From: Contact Centre (CRM) <contact@ribblevalley.gov.uk>
Sent: 04 September 2025 16:15
To: Planning
Subject: Planning Application Comments - 3/2025/0672 FS-Case-746605017

Planning Application Reference No.: 3/2025/0672

Address of Development: 12a knowsley road

AS BUILT SITE PLAN

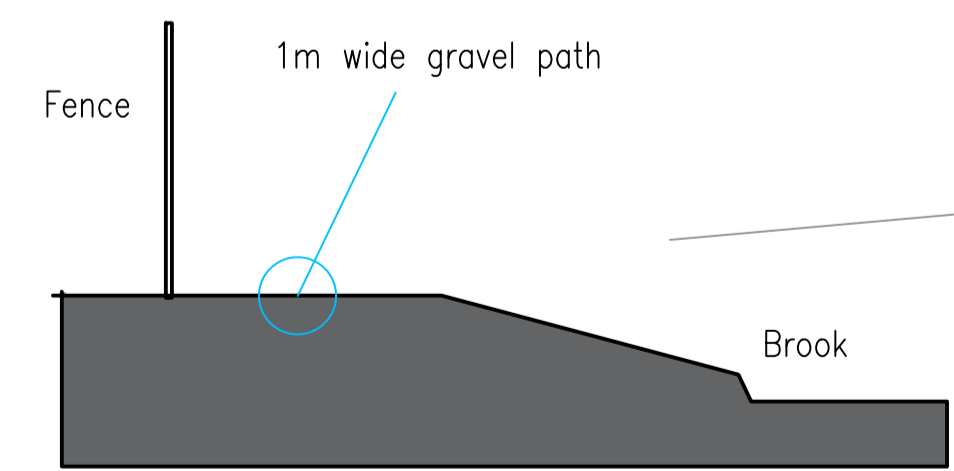
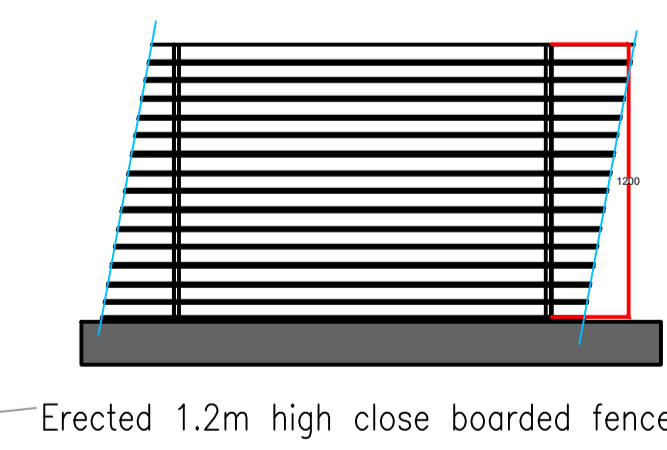
The proposed new fences create a difficult and “out of site, out of mind” barrier to the new owners and their legal responsibility to the maintenance of the watercourse banking area, trees, shrubs etc. This is also compounded in the fact that they have not included any gates in the fences to access the lower portion of each garden so clearly may suggest to the new owners it’s a “boundary fence”.. This was the reason no fencing was specified on the original plans and certainly will not make the boundaries clear to new owners, as [REDACTED], [REDACTED] sold, who thought [REDACTED] “belonged to the council”. Whilst I fully accept the responsibility is on the individual owner to understand the boundaries on their properties the fences now erected have created areas that are unclear and could create potential issues in the future that will be difficult to rectify once the developers have gone and the properties sold.

I would also say the fencing that has now been erected creates a another issue. The developer Mr Coupland had been informed and agreed to repair the banking on his land which is his responsibility, during development [REDACTED] had pointed the collapsed area out to him. Since then [REDACTED] has had several conversations with the builder but all those have resulted in no action. This is also despite several letters and emails sent at the beginning of the project to and from LCC Flood Defence team to the developer..This was regarding the damaged banking that has now reduced water flow by nearly 50%. This is now causing the erosion of the opposing bank when substantial rainfall increases the flow drastically. Now the area has been “screened off” it will be difficult to access the banking with machinery given the small narrow”maintenance path”.

In addition I would comment that the erection of the fence reduces the car parking area. The main comments from the Highways Agency on the re-submitted plans was that the number of car parking spaces must include a turning circle so that vehicles are not reversing into the highway. The fencing has reduced the area so that the 7 spaces of regulation size and a turning circle agreed at planning will be difficult to achieve.

The fences create a difficult and “out of site, out of mind” barrier to the new and owners and their legal responsibility to the maintenance of the watercourse banking area, trees, shrubs i mentioned before. This is also compounded in the fact that they have included no gates in the fences to access the lower portion of each garden so clearly may suggest to the new owners it’s a “boundary fence”..

This was the reason no fencing was specified on the original plans and certainly will not make the boundaries clear to new owners. This was found when [REDACTED] sold, who thought the land behind [REDACTED]. Whilst I fully accept the responsibility is on the individual owner to understand the boundaries on their properties the fences now erected have created areas that are unclear and potential issues in the future will be difficult to rectify once the developers have gone and the properties sold.

The developer Mr Coupland had originally agreed to repair the banking on his land [REDACTED]. Since then [REDACTED] with the (Builder) but all those have resulted in no action. This is also despite several letters and emails sent at the beginning of the project to and from LCC Flood Defence team to the developer.. This was regarding the damaged banking that has reduced water flow by nearly 50%. This is now causing the erosion of the opposing bank when substantial rainfall increases the flow drastically. This makes the repairs prior to the sale of the properties difficult to get to having now “screened the areas off” with a tiny access path which no machinery can possibly access.

Also the comments from the Highways Agency on the re-submitted plans state the number of car parking spaces must include a turning circle so that vehicles are not reversing into the highway. as can now be seen the area that the fences now encroach on has been reduced and that the 7 spaces of regulation size and the turning circle agreed at planning may be difficult to achieve if these fences remain.

Comments: I would like to comment on the erection of the boundary fence by the applicant. All the properties including the former showley brook care home that have the brook as their legal boundary line ([REDACTED]) have a responsibility under riparian ownership to look after and maintain the undergrowth and banking maintenance to reduce the risk of flooding and banking erosion. The banking on the side of 12a Knowsley road has collapsed over the years and [REDACTED] by mr coupland that this would be repaired . It was never done. (Letters have been sent to the applicant/builder from Lancashire county council flood risk management team to remind the developers about their responsibility) Now with the fencing erected this would be very difficult to do.. Under the original application it was stated no fencing was to be erected along the rear of the properties . In doing so is very confusing to the new purchasers as to their future responsibilities of banking/ brook care. The fencing erection gives the illusion that the property boundary stops at the fencing , which it does not . If the boundary line is changed , who will then be responsible for the future maintenance of the banking and brook which will lead to future erosion of the banking and increase the risk of surrounding property flood damage .
